BR/281/21/L

Berghestede House 1 Shripney Road Bognor Regis PO22 9LW

Replacement of existing garden room with timber framed garden room. (This application may affect the setting of a listed building).

Drawing Number:
P022 PR1

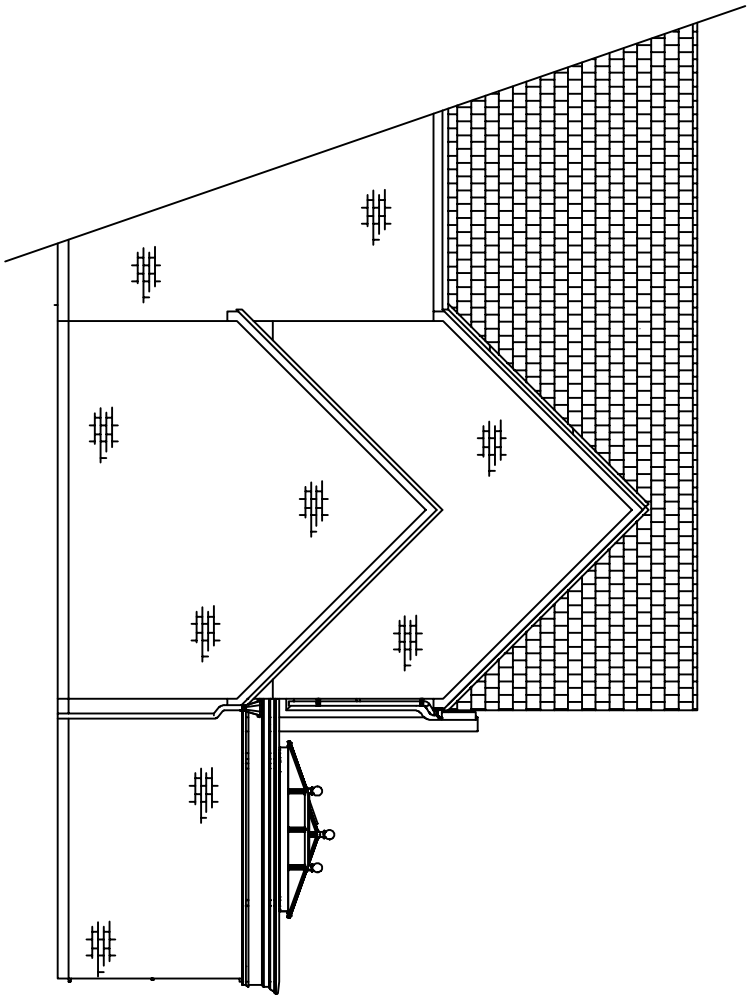
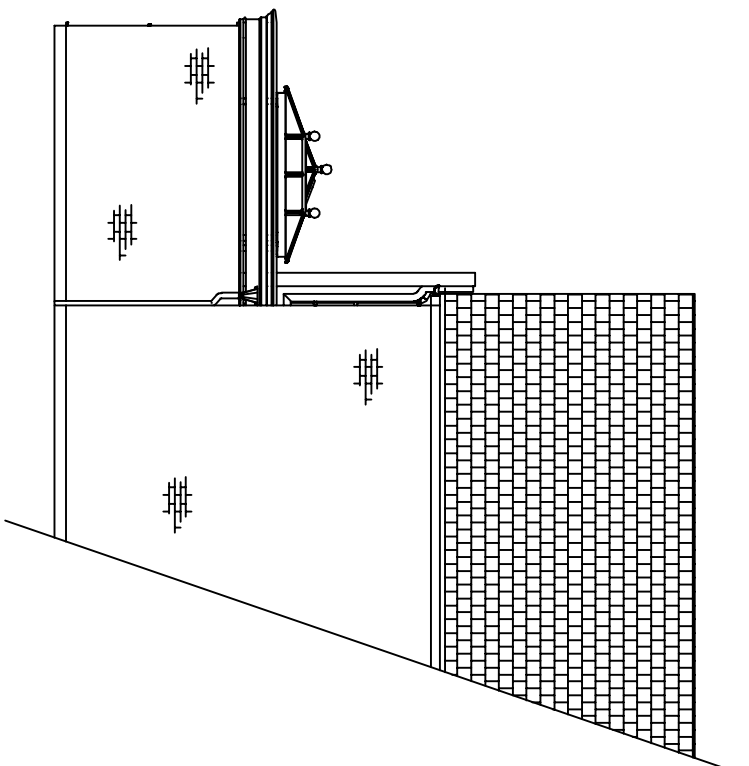
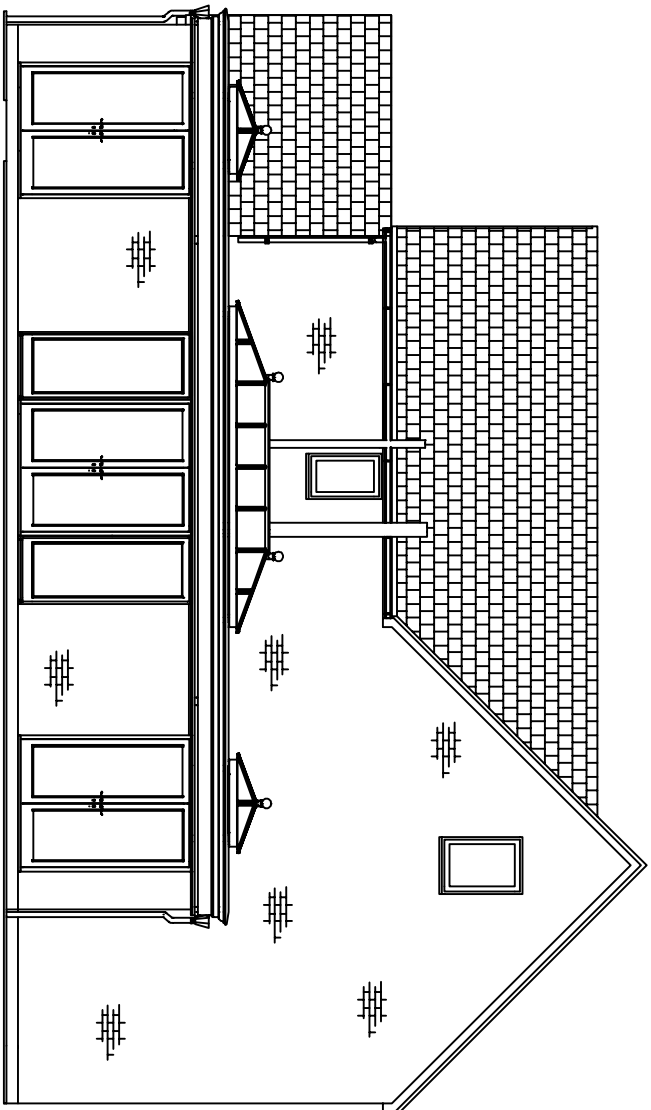
I am unable to find any details of the proposed French doors and as a result would require some further information in order to ensure that they are appropriate for a listed building. Such details

can be provided by way of condition and would include elements such as their materials, decorative/protective finish, cross section of frame etc to an appropriate scale etc. The brick work should also match the existing.
